**OBJECTION
UNIVERSITY OF NEWCASTLE CITY CAMPUS CONCEPT PLAN
CONCEPT APPLICATION – STATE SIGNIFICANT DEVELOPMENT
SSD9262**

On behalf of the Strata Committee for 522 Hunter Street Newcastle, Resolve Urban Planning hereby objects to the Concept Approval, as amended, sought for the University of Newcastle City Campus proposal. The objection is formed following review of the revised documentation available from the Department of Planning, Industry and Environment, provided in response to former submissions.

Figure 3.6 Setbacks Diagram

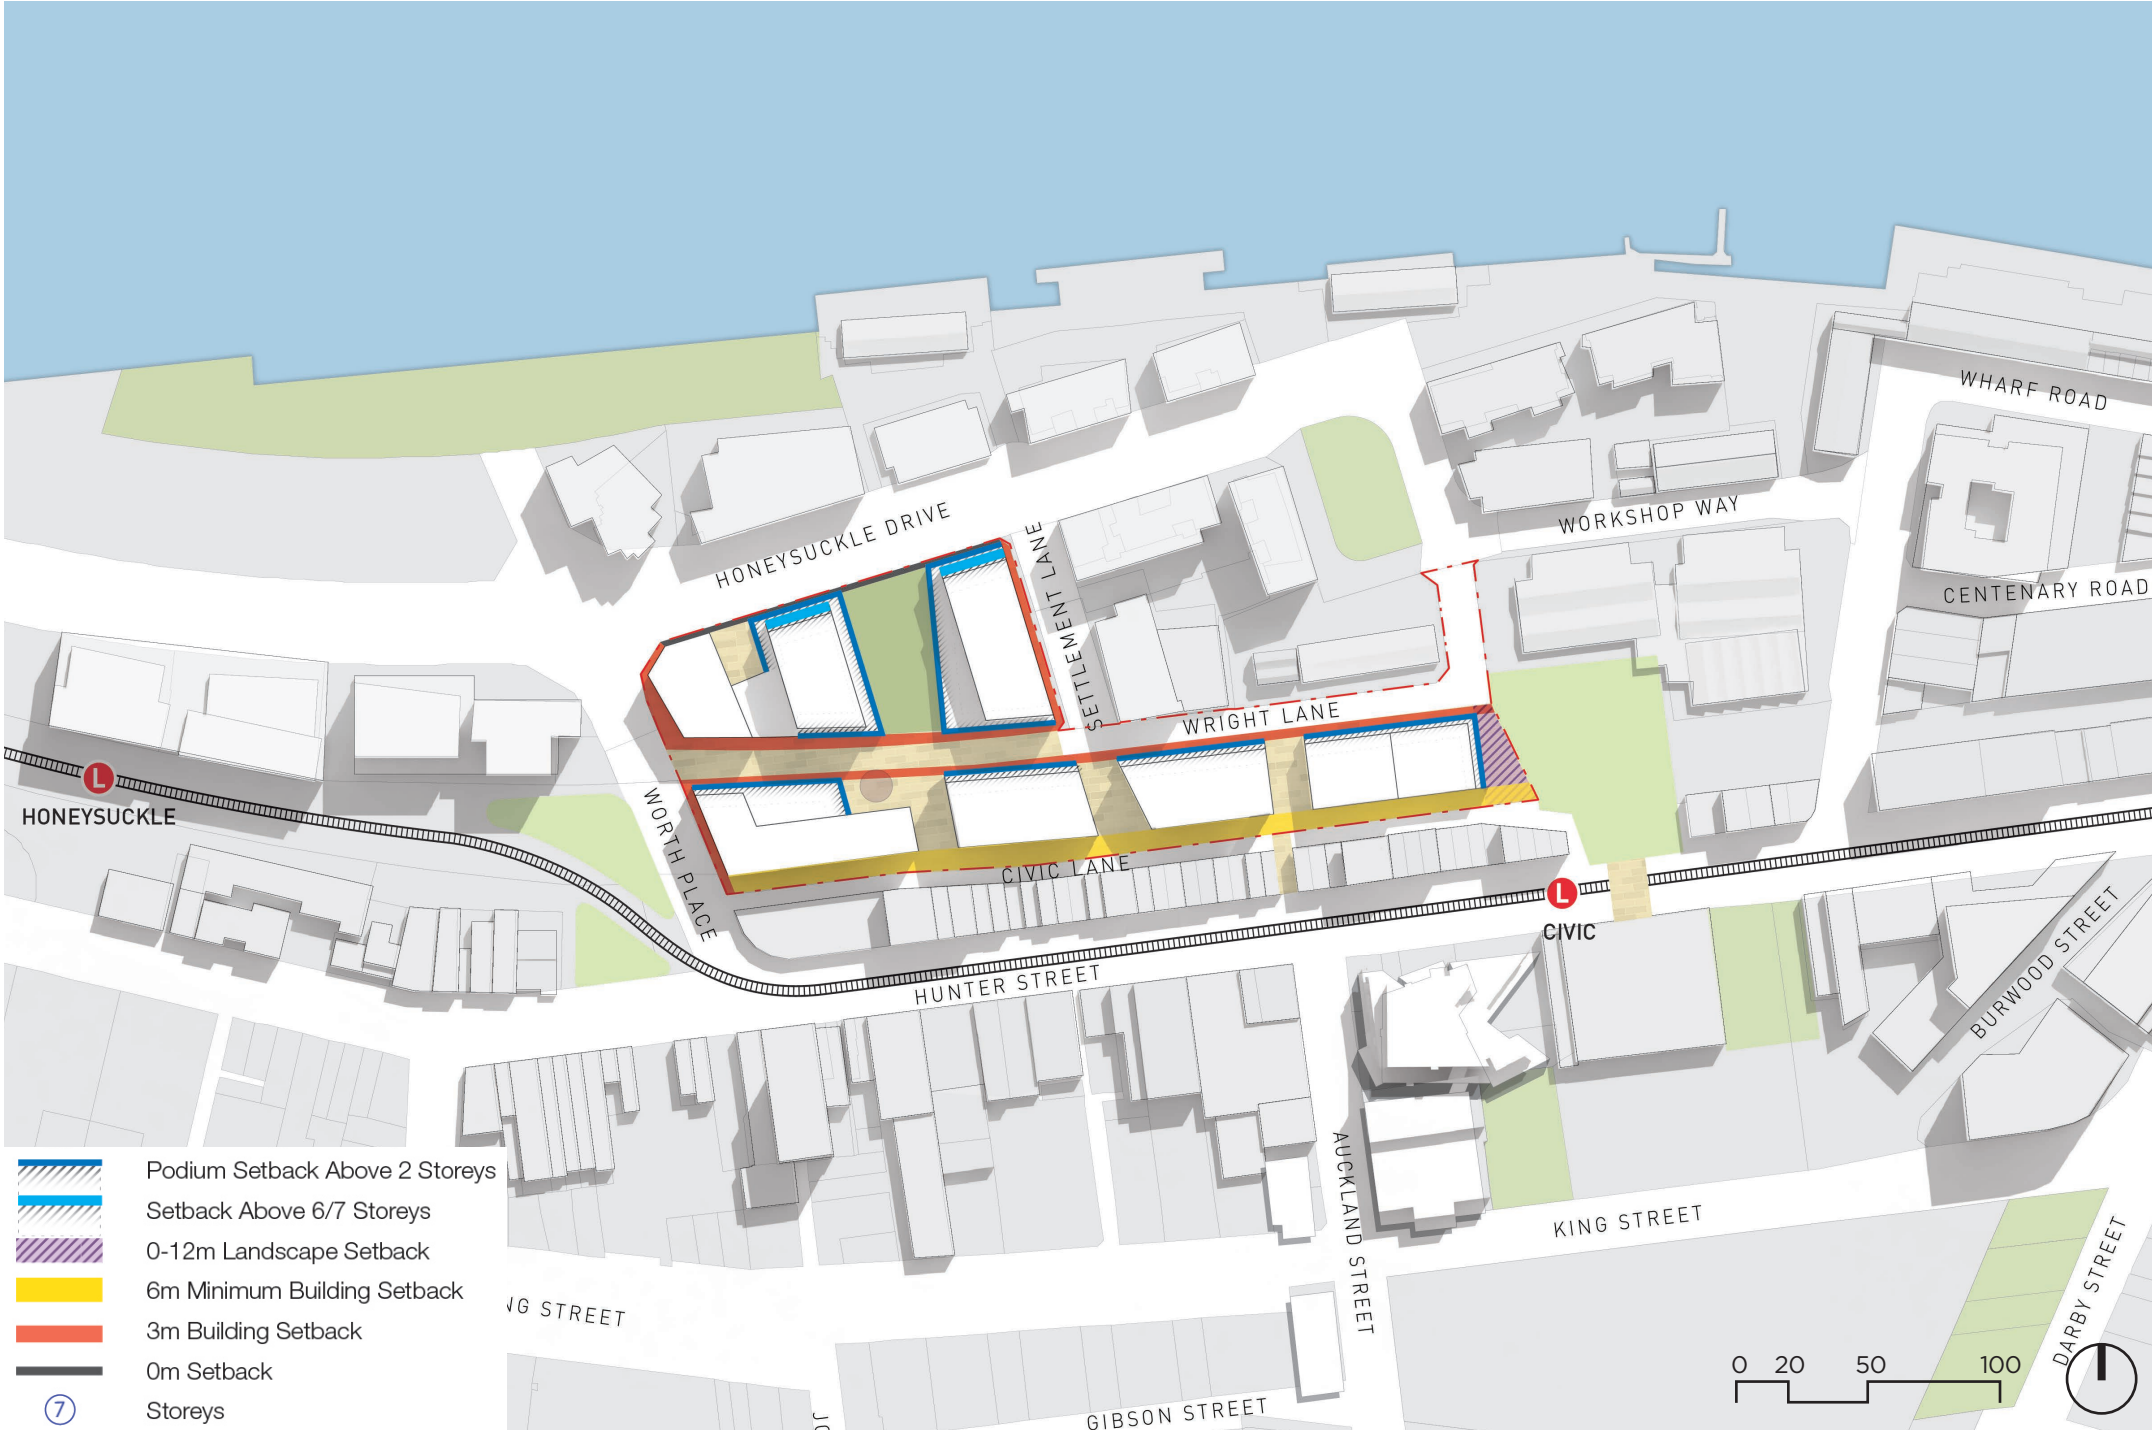
1. The revised concept plans illustrate a reduced setback to Civic Lane. Relative to the former documentation. The former plans indicated a 6m setback to Civic Lane, the proposal now seeks a maximum 5m setback to the lane.

The total setback to 522 Hunter Street will be 12m, being the minimum separation required between habitable rooms in a 4 storey development in accordance with the ADG.

Figure 7.7 Lot B Detail Plan

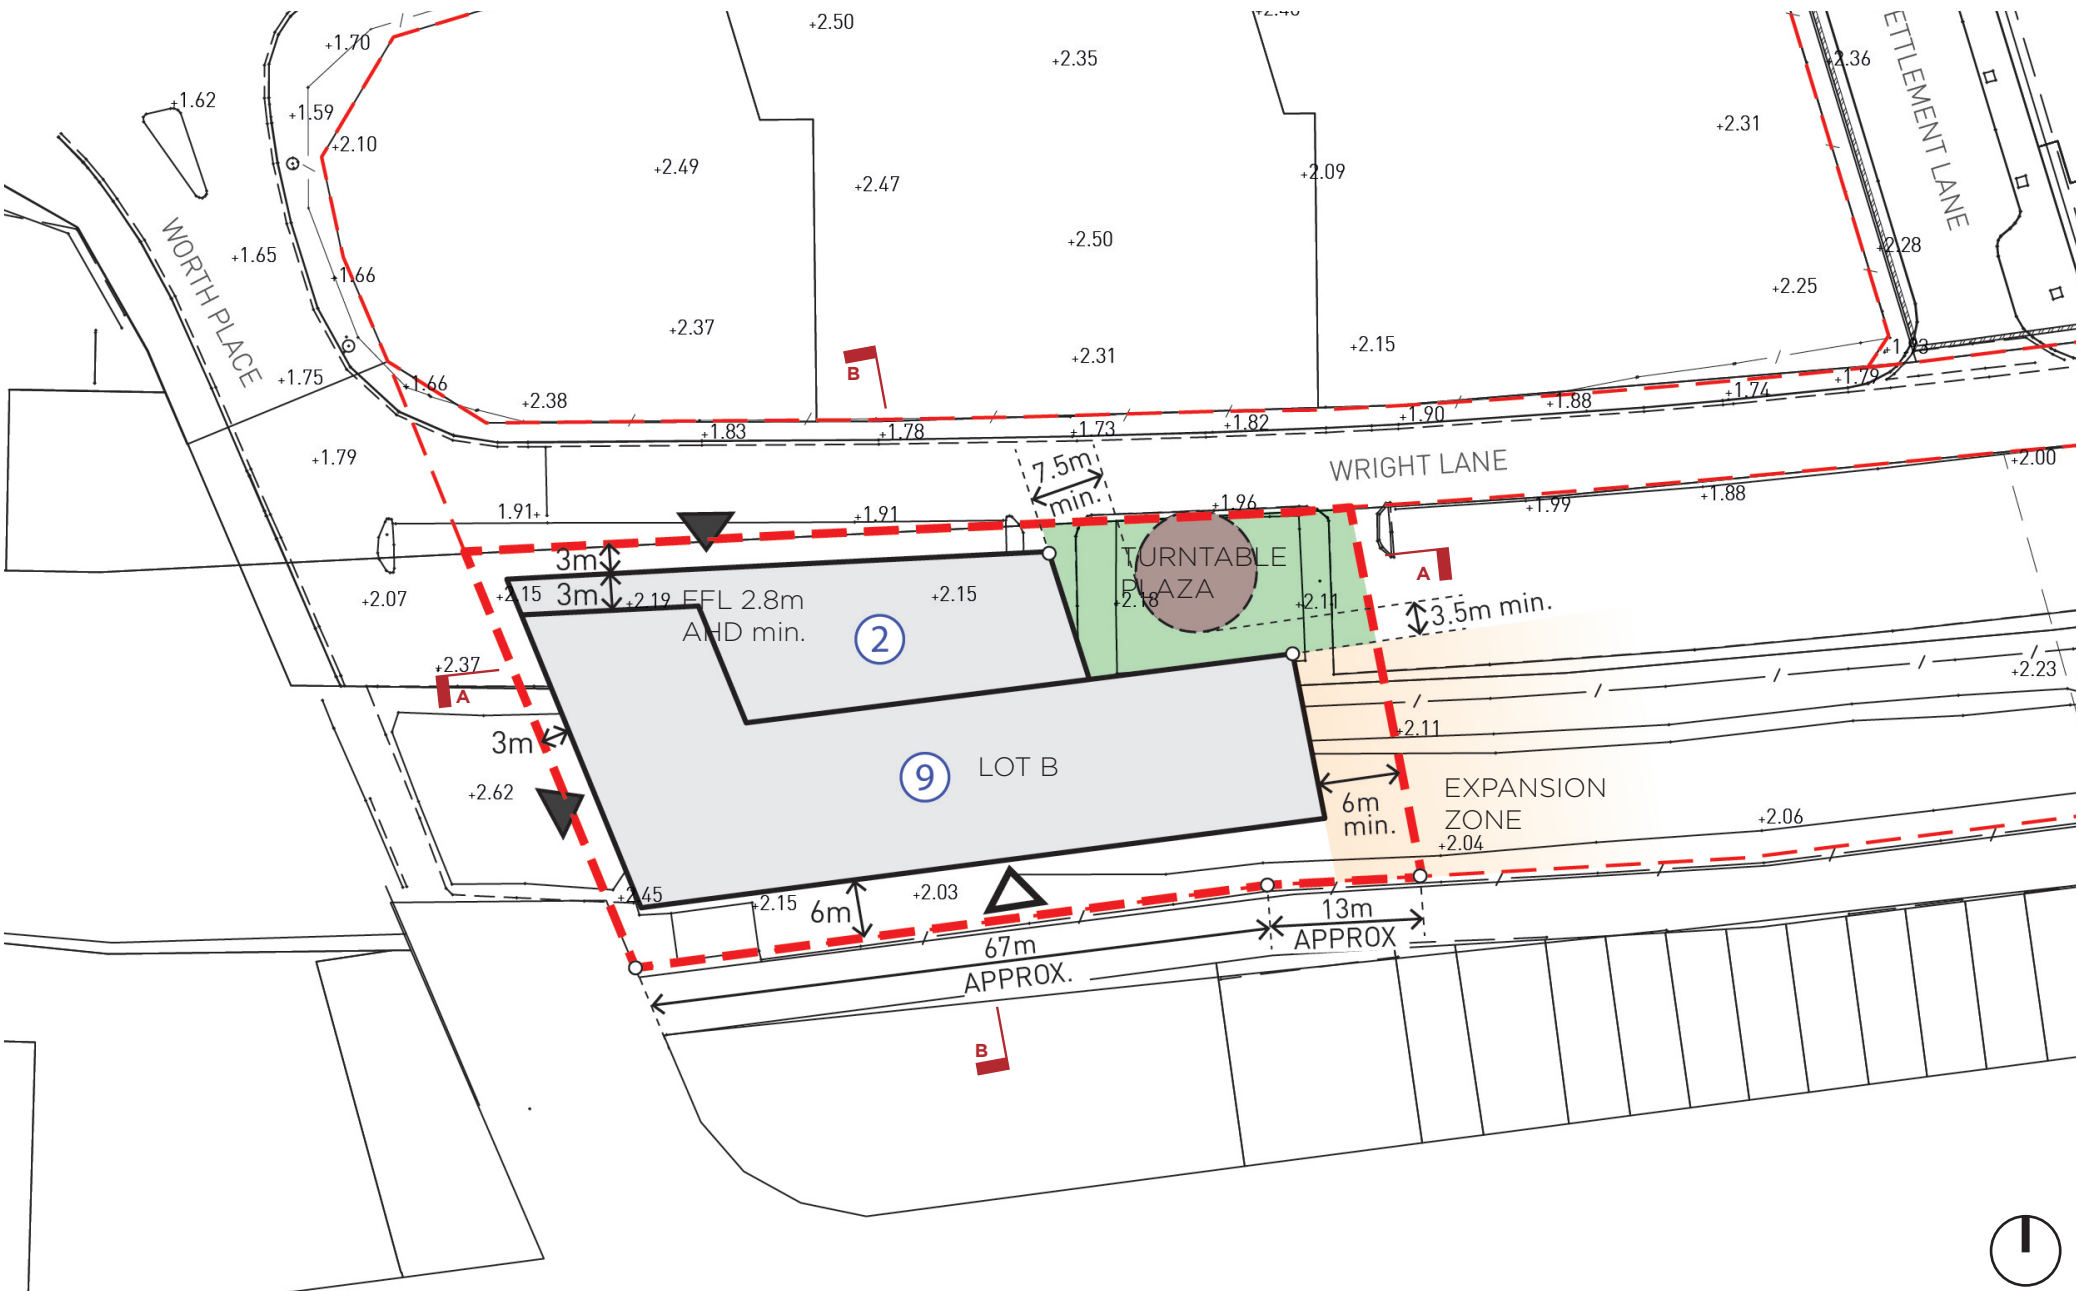
The revised design guidelines identify floors 3 and above of Building B for use as student accommodation. It would appear that the building footprint and depth will require a significant number of student rooms to have southern facing windows as their only source of light (making screening impractical).

The building footprint could therefore be readily altered to provide the necessary 18m separation between habitable rooms (from the ADG for buildings five storeys and greater in height), to protect the amenity of both the occupants of 522 Hunter Street and future student occupants.

2. The documentation provides no specific justification for the siting of Building B, being the identified student accommodation building. In accordance with the Design Guidelines the accommodation building is the highest building within the site yet remains sited in the area of greatest impact to adjoining allotments, given the existing/future development to its south.

3. The lot guideline information contained within the revised design guidelines refer to a possible expansion zone between buildings B and D. In the context of the significant loss of amenity already identified from these buildings there would be no opportunity for building expansion as generally suggested. This must be removed from the plans to avoid any doubt during the detailed design phase of these buildings.

Further, the identification of possible expansion zones between Buildings B and D is required to be removed from the concept plan. Any further expansion of the buildings, and subsequent reduction in the separation between the buildings, will only compound the potential view loss experienced within 522 Hunter Street.

Figure 7.13 Lot D Detail Plan

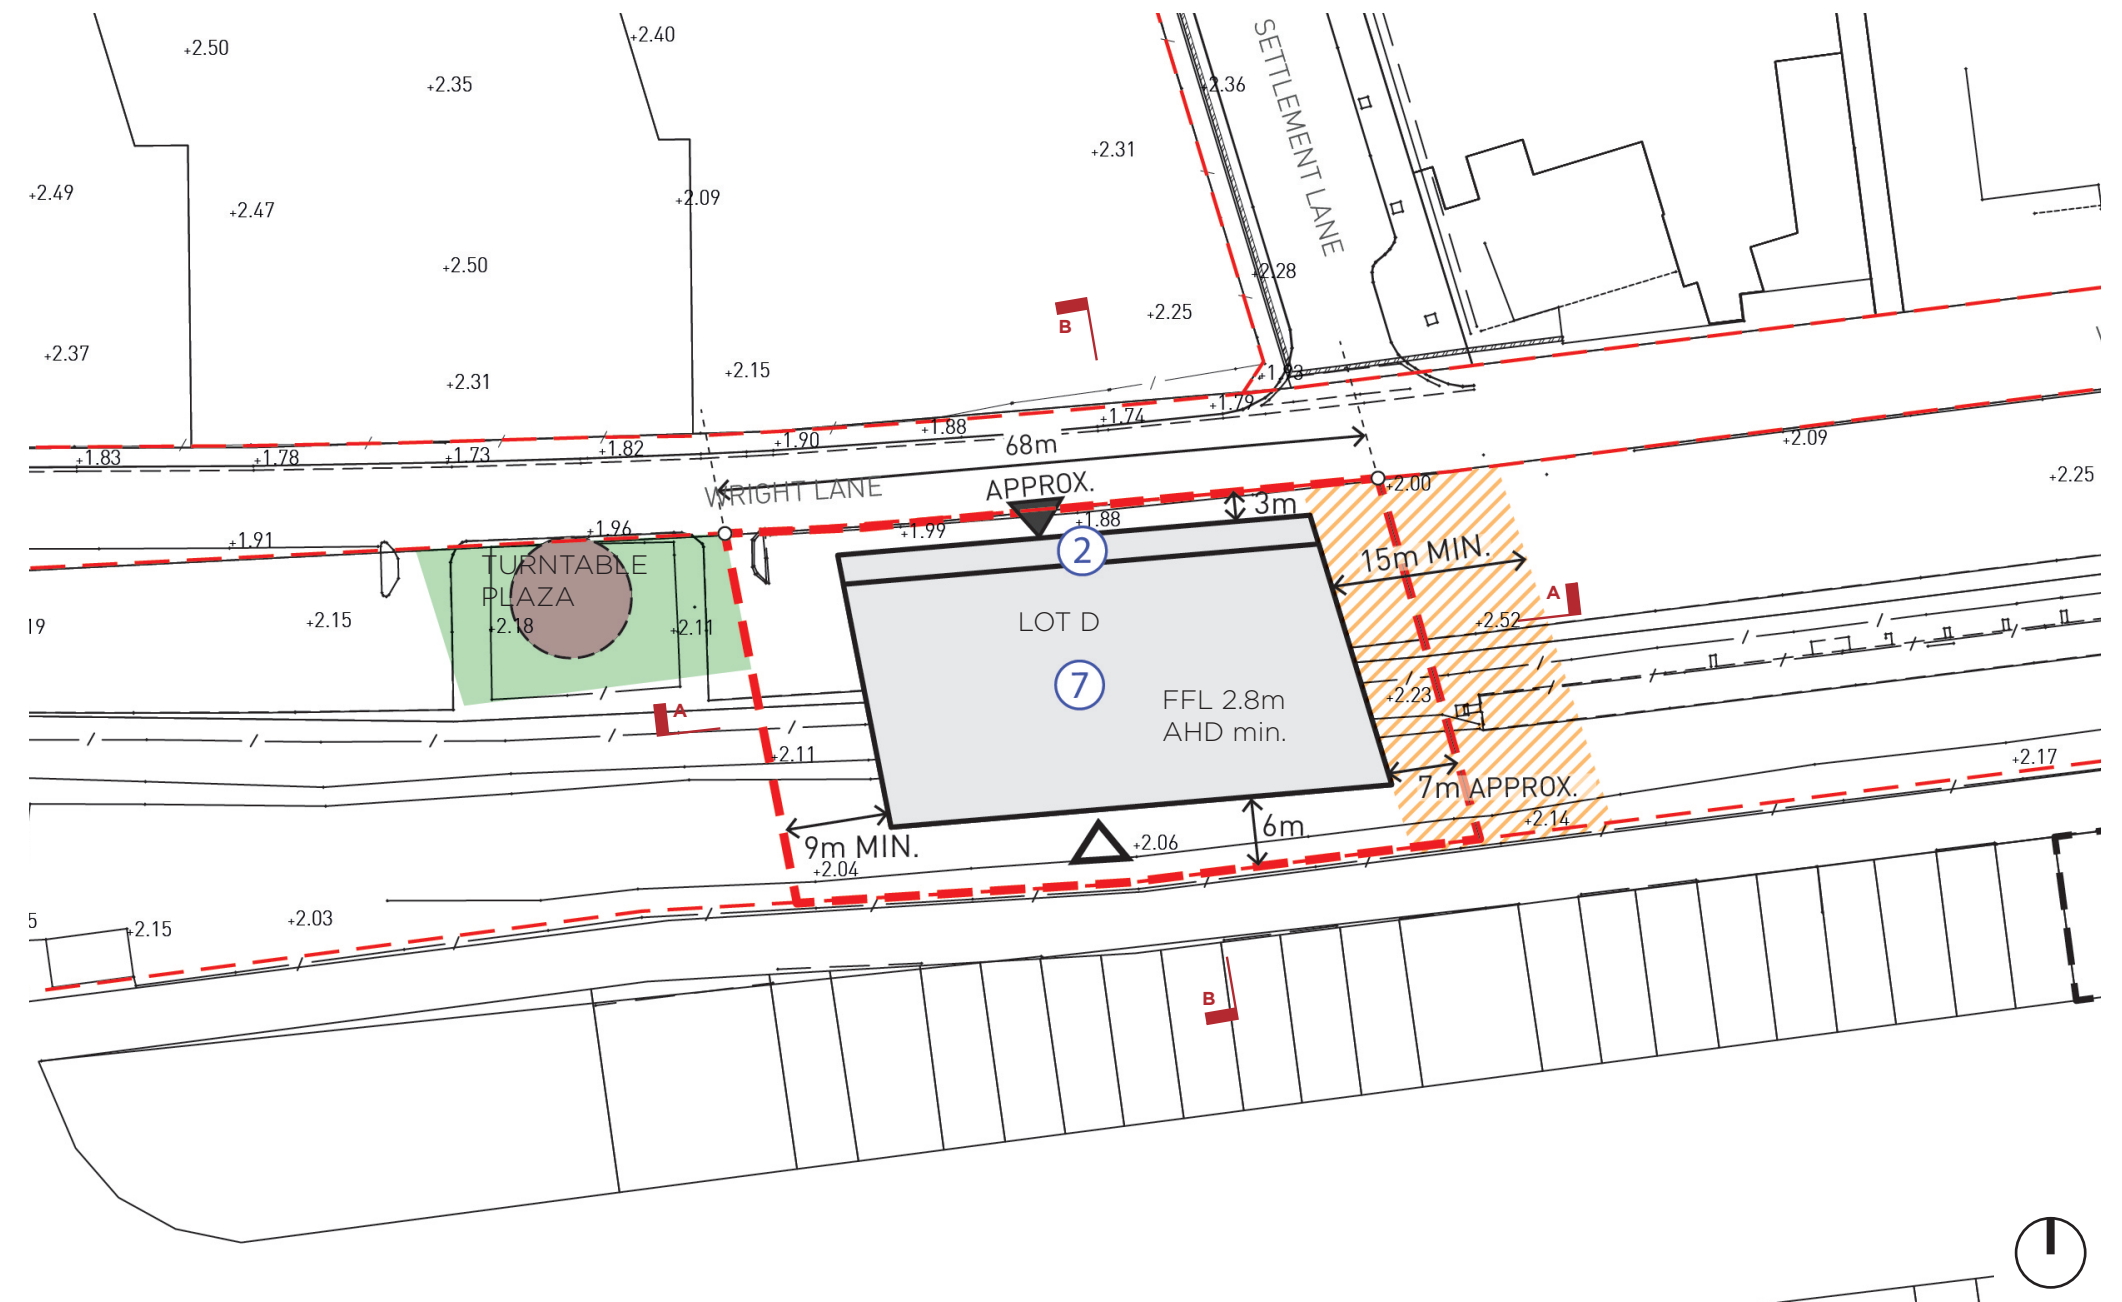
Whilst an increased separation is noted between Building B and D within the amended documentation made available by the Department, improved view sharing appears to only be possible via a greater increase in the building separation between Building B and D. This increased separation reflects the observations made in respect of overshadowing impacts.
